**From:** Bloomer, David <David.Bloomer@lancashire.gov.uk>  
**Sent:** 23 May 2018 10:51  
**To:** Adam Birkett  
**Cc:** LHS Customer Service; planning  
**Subject:** app3/2018/0263 10 Knowsley Road Wilpshire

The Proposal is for the subdivision of an existing care home into 5 dwellings ( 4 x 3 bed and 1 x 4 bed) The application form states that there are currently 4 parking spaces on site with the development proposing to provide a further 6 spaces to bring the total up to 10. Based on LCC's parking standards the proposed development would generate a requirement for 11 parking spaces.

drawing title: PROPOSED SITE PLAN		
scale: 1:200 @ A2		
drawn: DS	checked: PH	
date: 22/03/18		
project no: PHA/123	fig. no: 200	rev: -

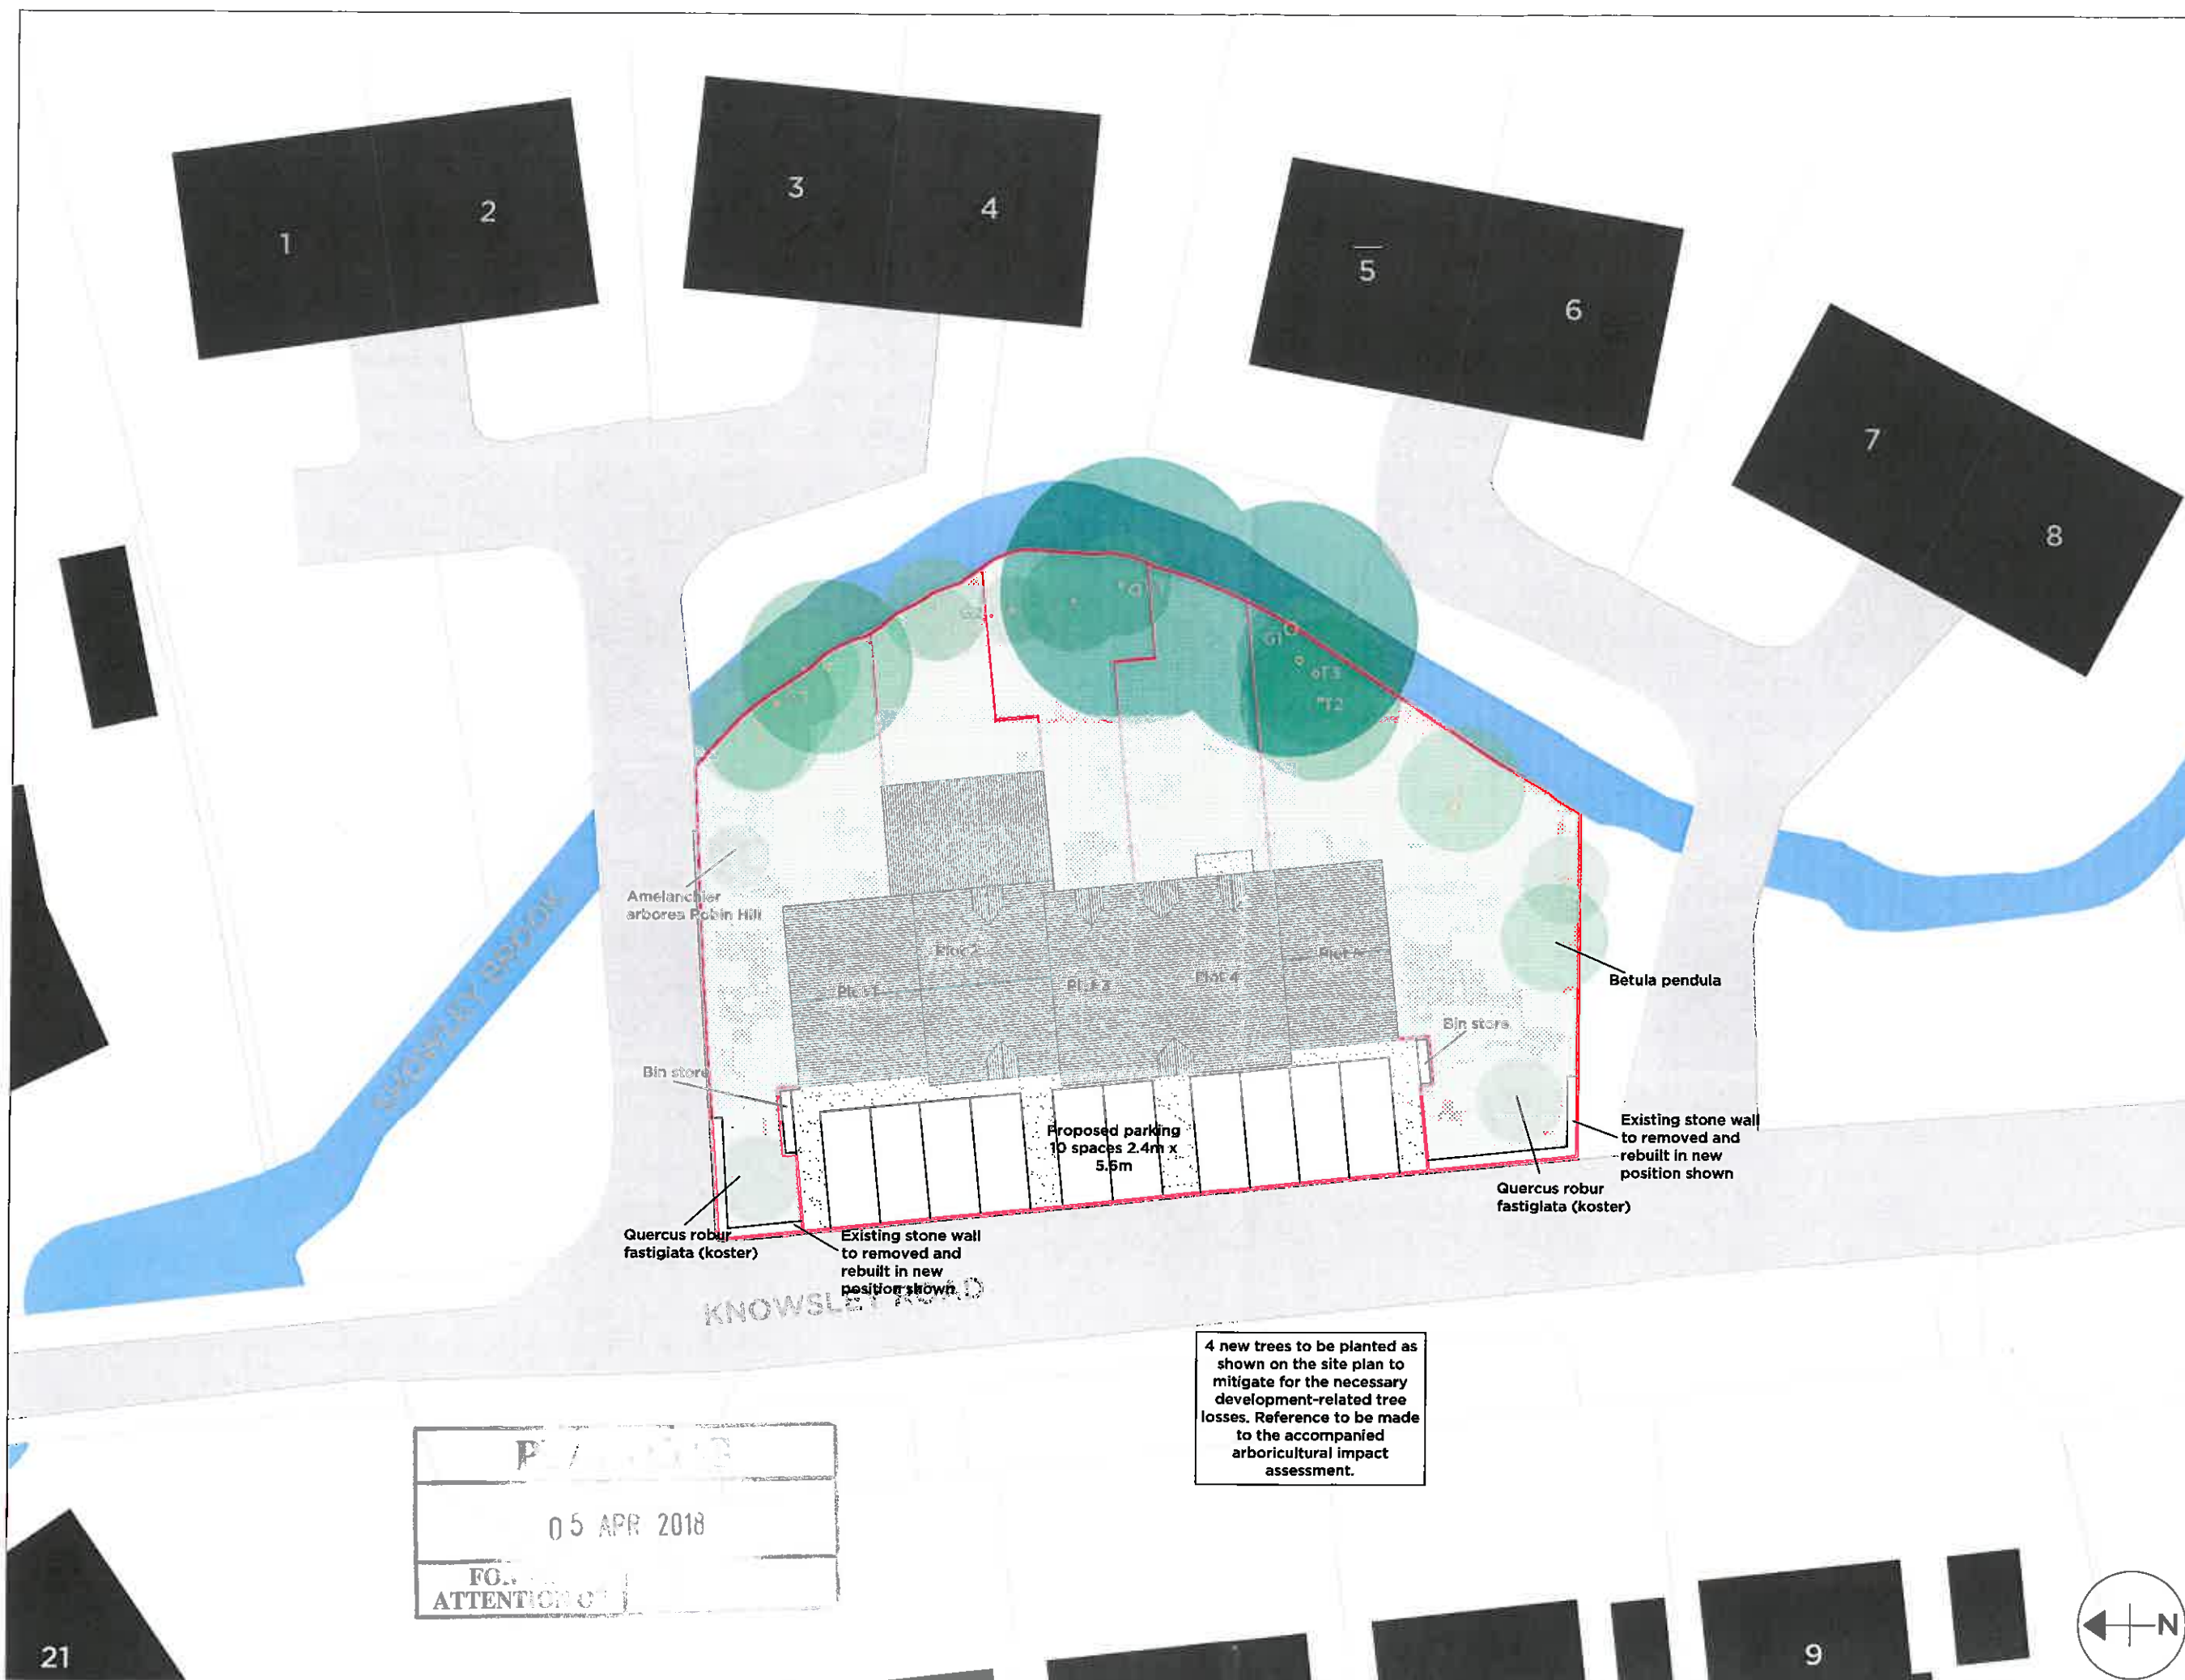
However the main concern and one which was raised during the pre-application discussions was the positioning of the proposed parking provision and the encroachment over the full width of the footway along the frontage of the site. This would not be acceptable for the following reasons

- 1 The loss of the footway would be detrimental to pedestrian safety
- 2 Visibility for vehicles emerging from the spaces ( likely to be reversing) will be severely impaired by adjacent vehicles.
- 3 loading and unloading luggage and shopping etc from the boot of parked vehicles would place pedestrians within the live carriageway.
- 4 Visibility for vehicles exiting Clifton Grove will be compromised
- 5 It is a usual requirement on bin collection days for the bins to be moved to the kerb edge prior to collection. The proposed layout does not allow for this and the likelihood it that these bins will be moved onto the carriageway to await collection.

In the pre-application response doubt was raised about whether or not the footway formed part of the adopted highway. Anecdotal evidence from a colleague suggest that the full S38 procedure was not followed through due to a dispute between the developer and highway authority regarding the surfacing materials. However notwithstanding whether or not the footway is adopted highway the fact remains that it was a feature of the original application for the care home and has been a benefit to all its users and the public at large and will remain essential to the safety and amenity of the residents of the care home or any future uses of the site and it is for this reason I would have to recommend that the application be refused on highway safety grounds
